# Building R1 (SSD 6513)

## Attachment A – Detailed Response to Submissions

Response to Schedule 1: Additional matters identified by the Department of Planning and Environment.

Lot 5 DP.876514 Boundary ---

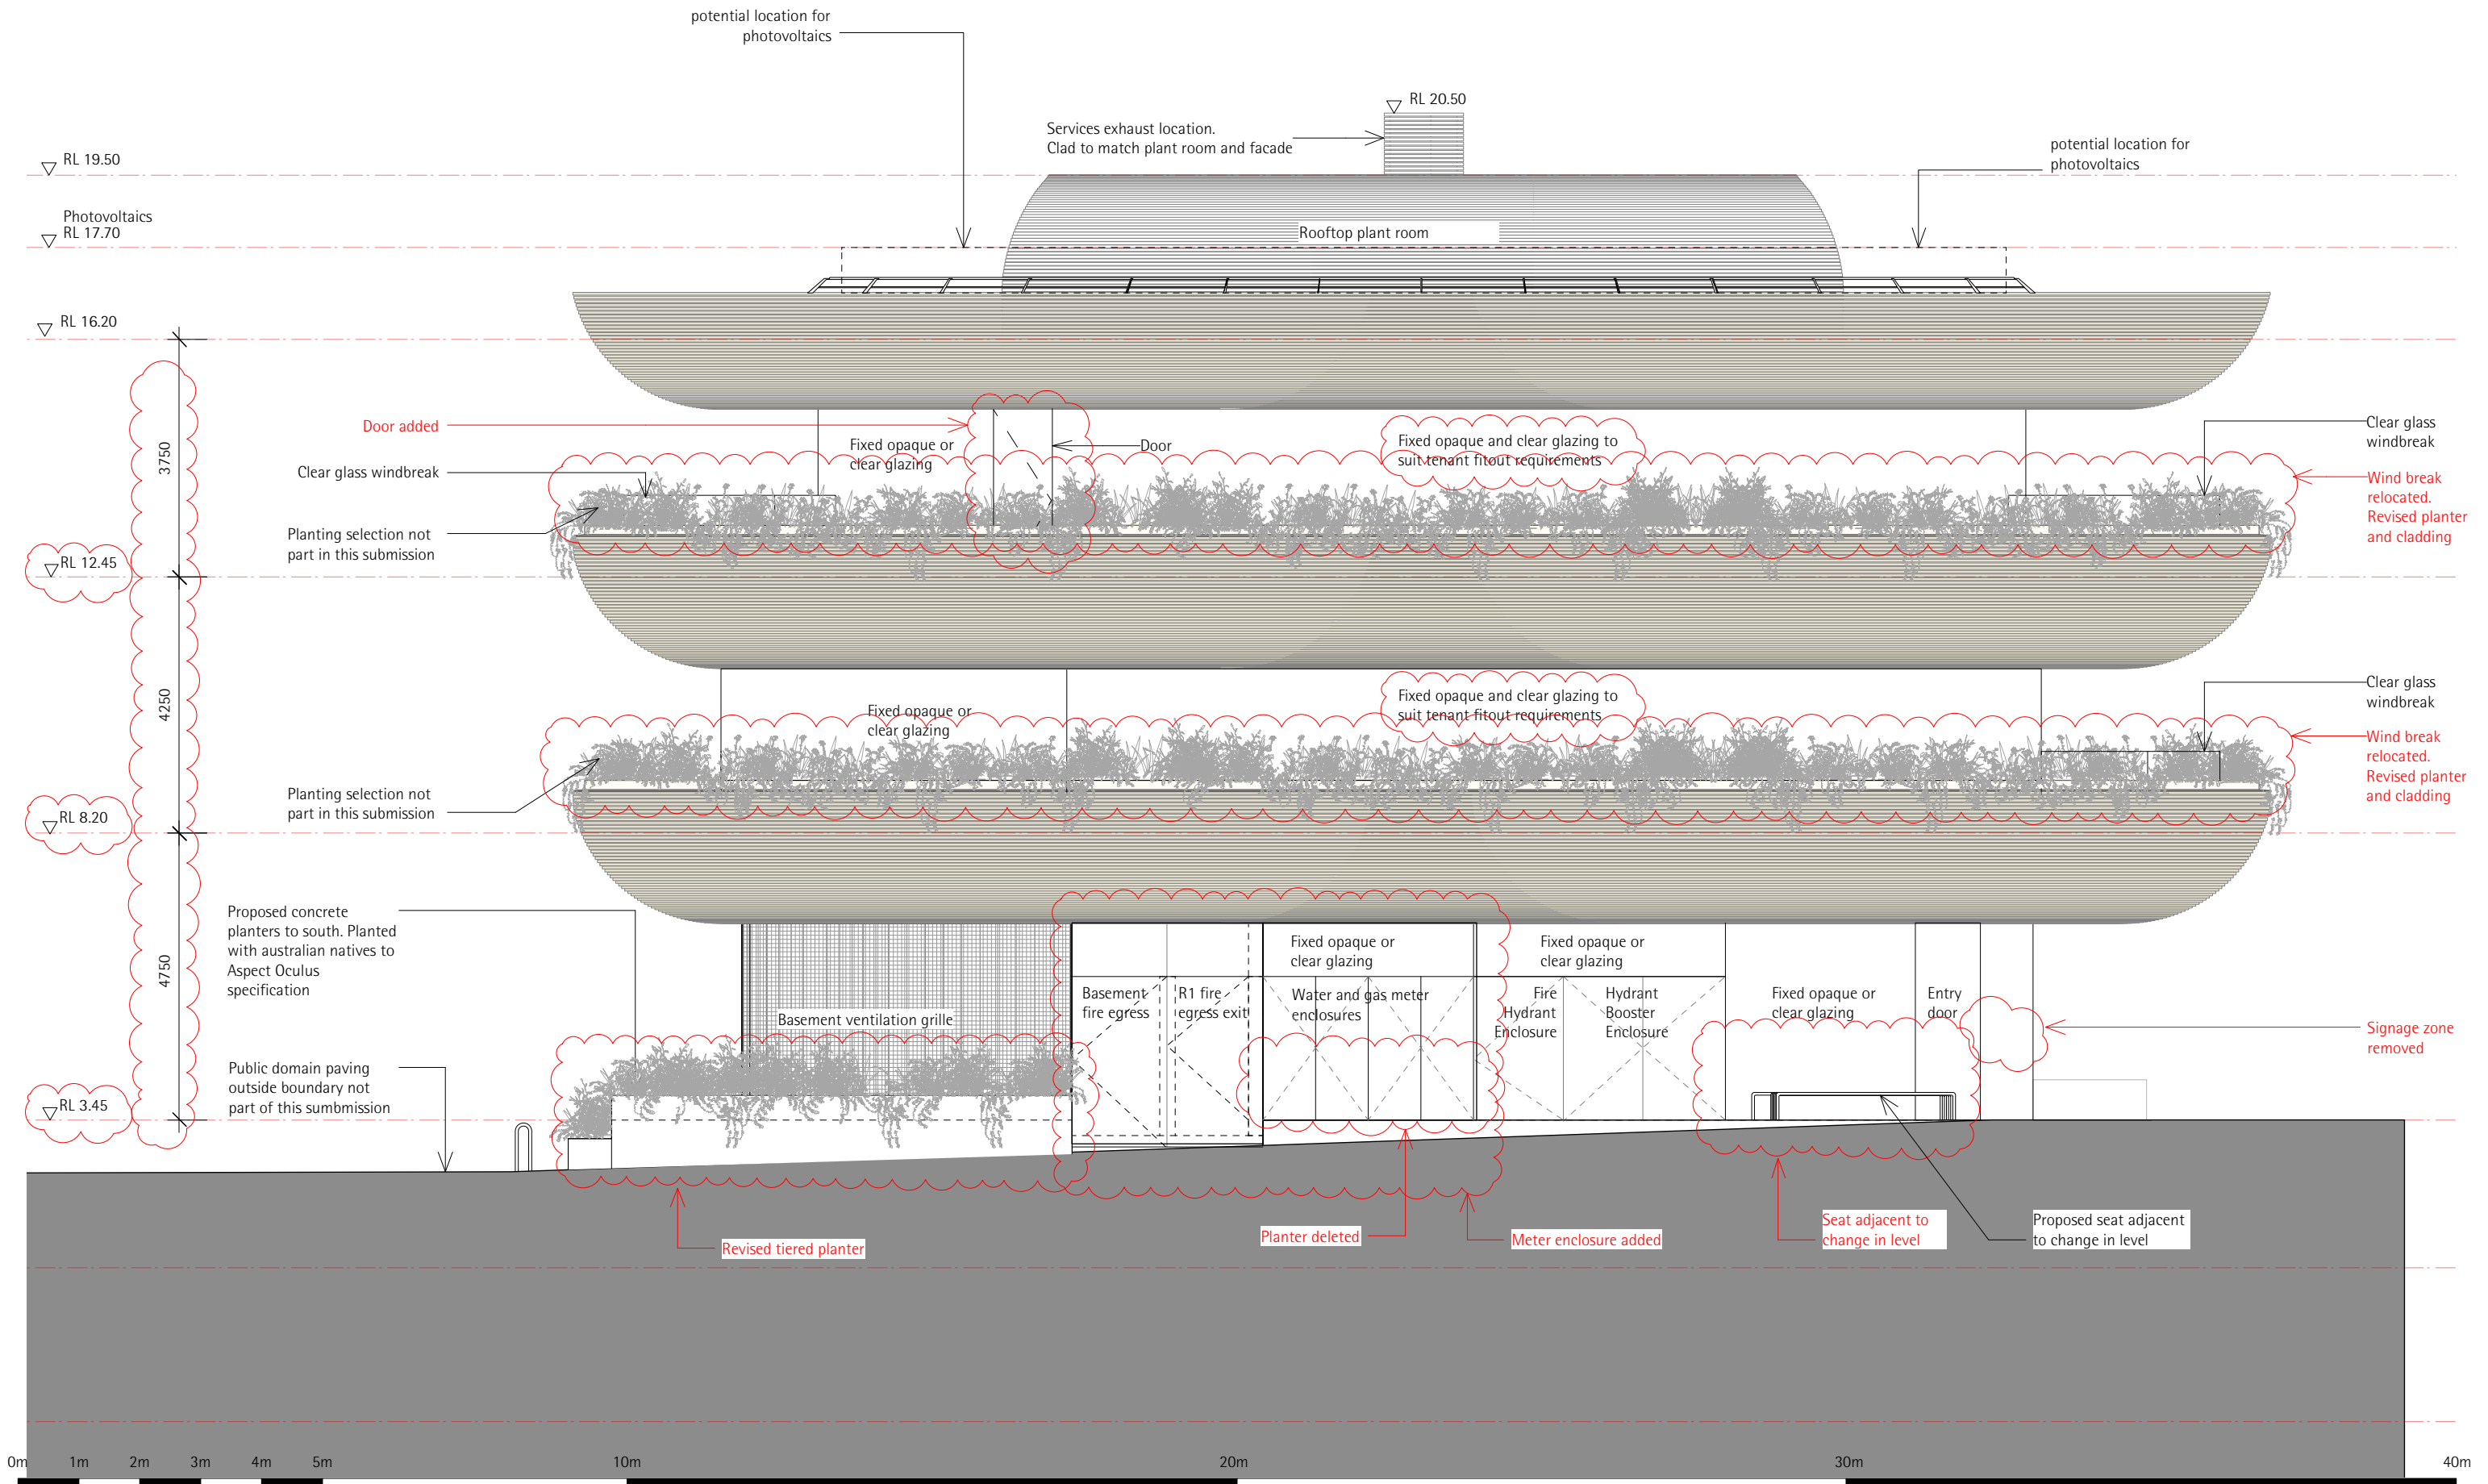
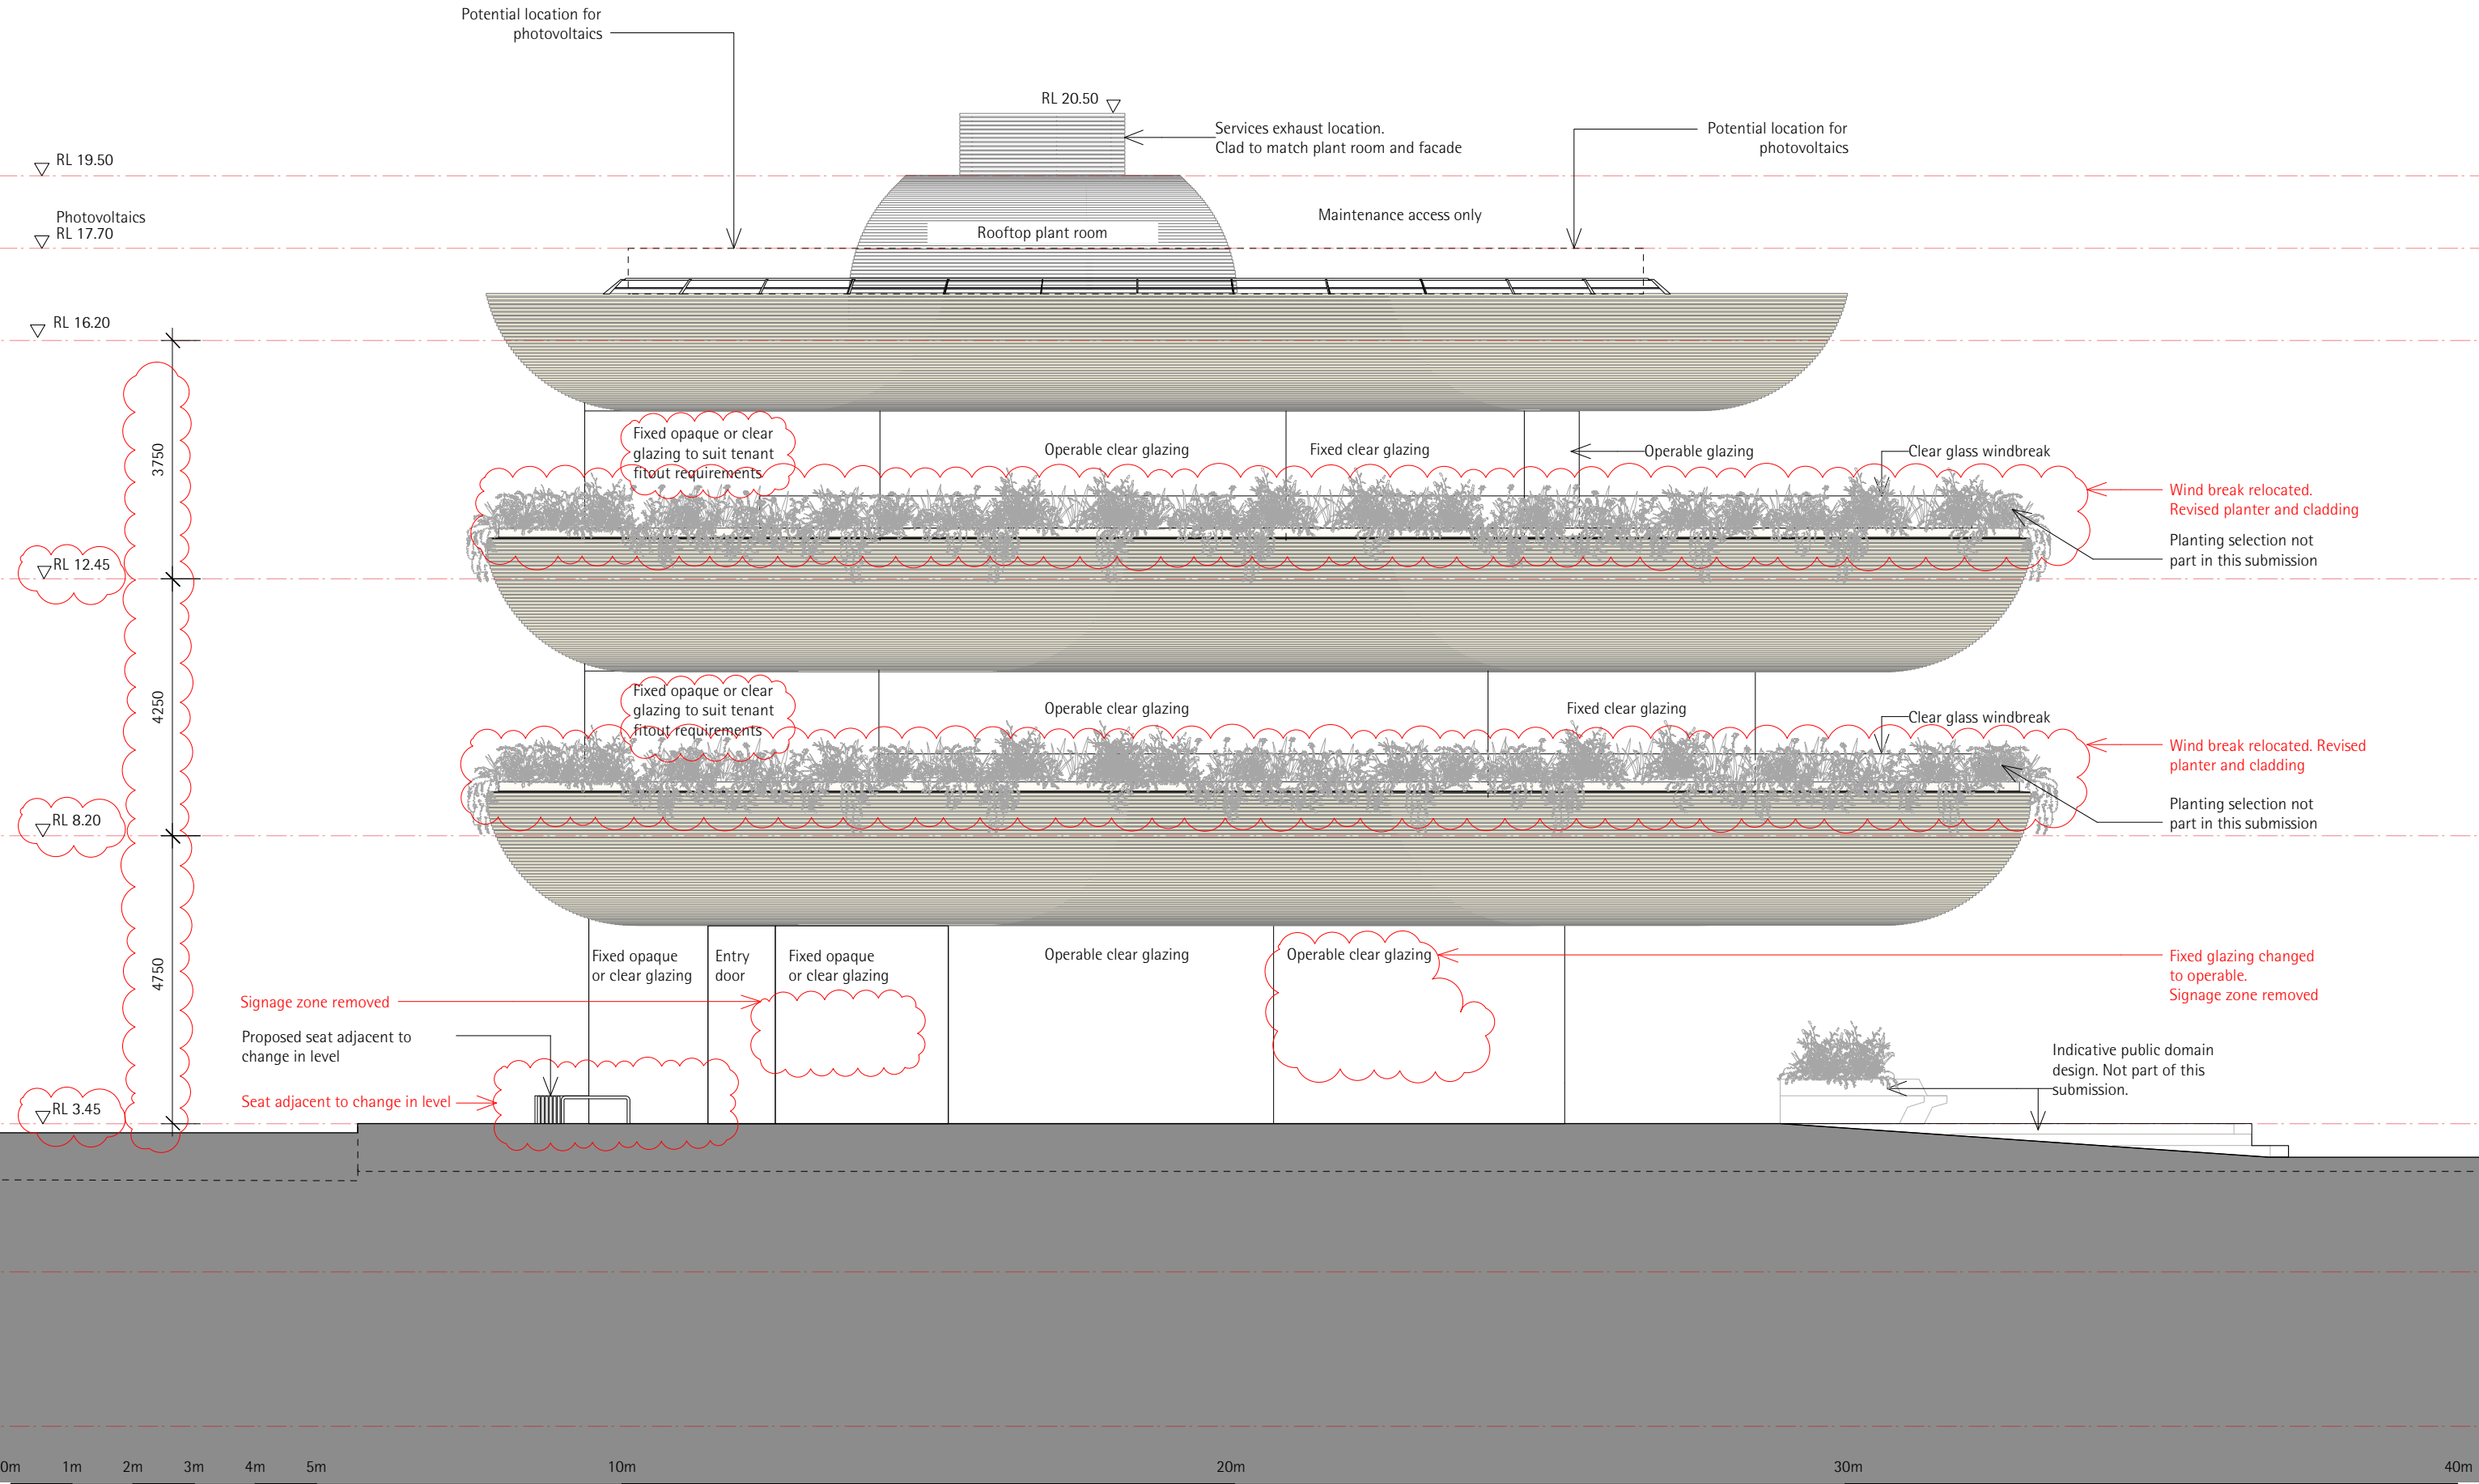
| Key Issues Raised |   | Lend Lease Response  |
|-------------------|---|--|
| 3                 | <p><b>Design Issues</b></p> <p>Although building R1 is conceived as an object building, to be experienced in-the-round, the ground floor uses and elevations to Lime Street and the south indicate largely blank, inactivated facades.</p>  | <p>A number of constraints exist for Building R1, including the need to accommodate the Shared Services Riser' which protrudes through to above-ground on the Building R1 site, and also the need to provide a services to support the building. The provision of services on the ground level is unavoidable and is common practice in all new developments. The location of these services has been contained to a small percentage of the façade. Through focusing these services to a small portion of the façade, it allows for a more contiguous and usable ground level that focuses the activation at the higher priority pedestrians areas of the Foreshore Promenade and Exchange Plan (formerly Transport Place).</p> <p>Careful landscaping treatments, including planter boxes, have been provided to soften the presence of these required services in the façade.</p> |
